from
**Southern
Water**

Our ref
PLAN-041641

Proposal: Approval of details reserved by condition imposed under AB/4/18/PL relating to conditions 4-surface water drainage, 5-maintenance & management of surface water drainage & 7-Construction Management Plan.

Site: AB/112/21/DOC: - 1-7 Canada Road, Arundel, BN18 9HZ.

Drawing Status	FOR APPROVAL
Client	Arun District Council
Project	Canada Road, Arundel, BN18 9HZ
Drawing Title	Topographical Survey, Proposed Levels & Drainage GA
Scale	As Shown
Date	06/04/21
Drawn By	MJA
Checked By	MJA
Drawing No.	D1955-400
Rev.	C

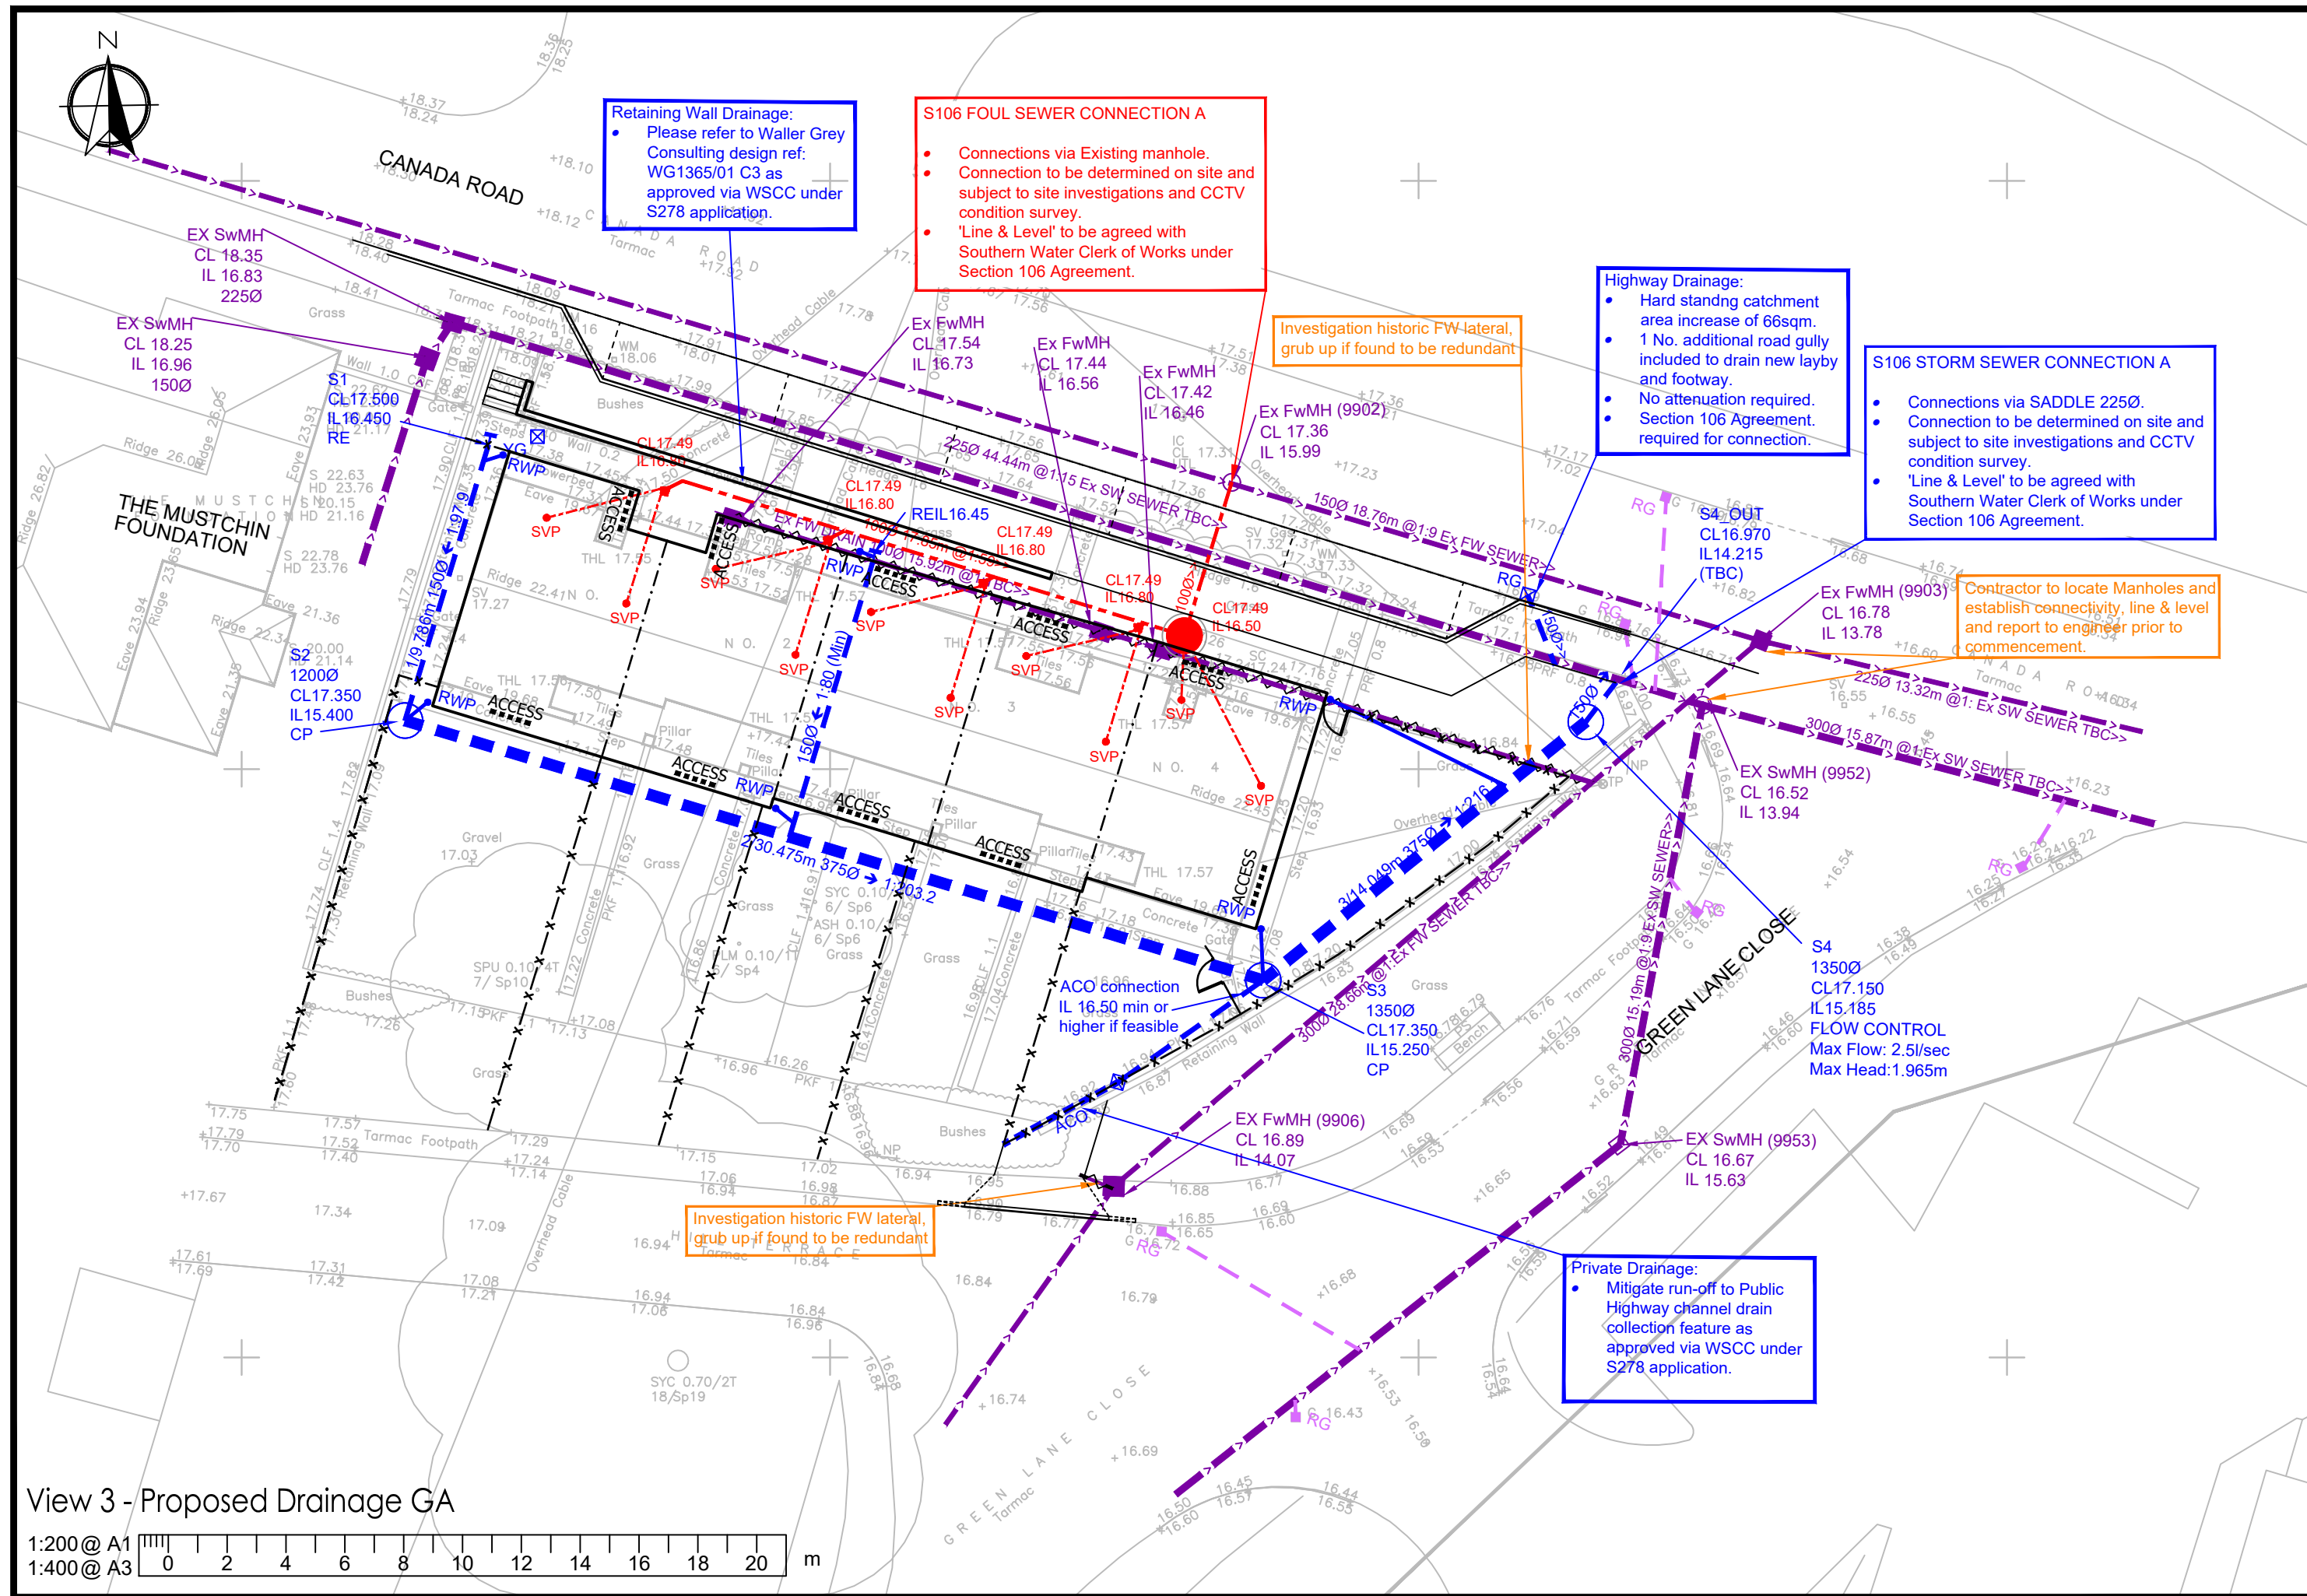
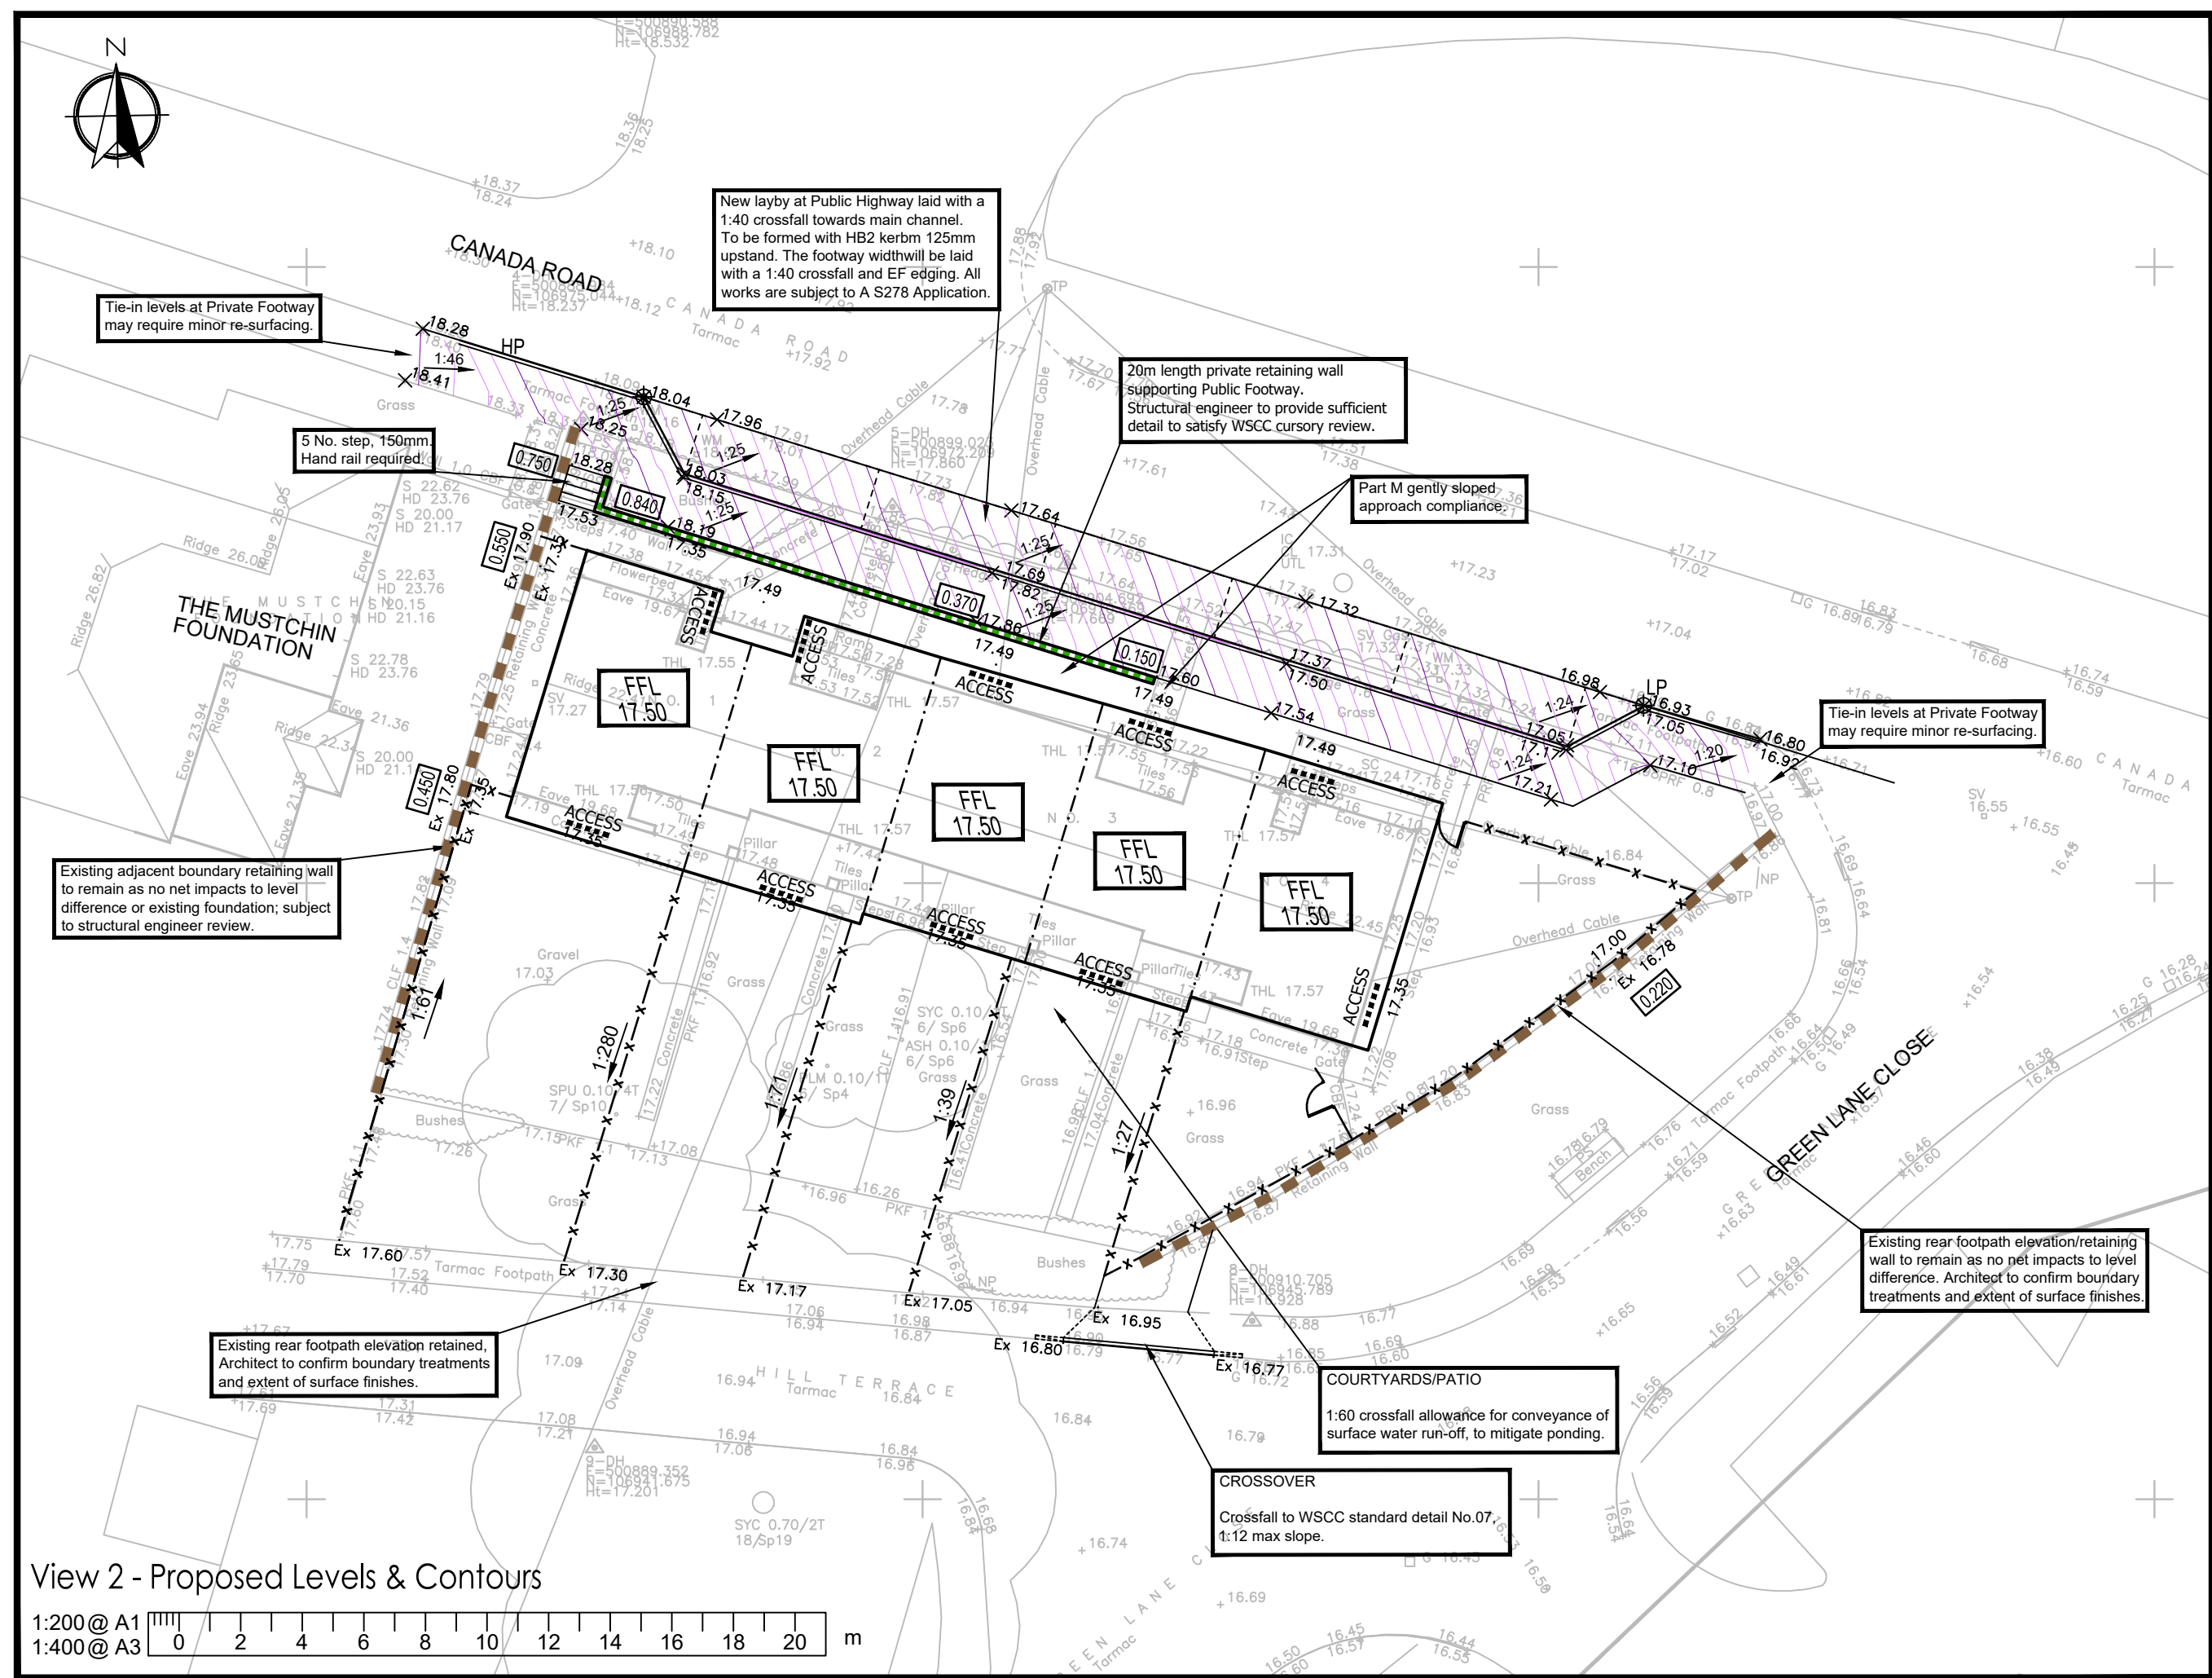
The submitted drainage layout (Drawing No. D1955-4 Rev B) indicates that the proposed surface water flows from the building are reduced from the existing contributing flows limiting to no greater than 2.5l/s to public surface water sewers. Surface water may be discharged to the existing sewer, provided the rate of discharge to sewer is no greater than existing contributing flows.
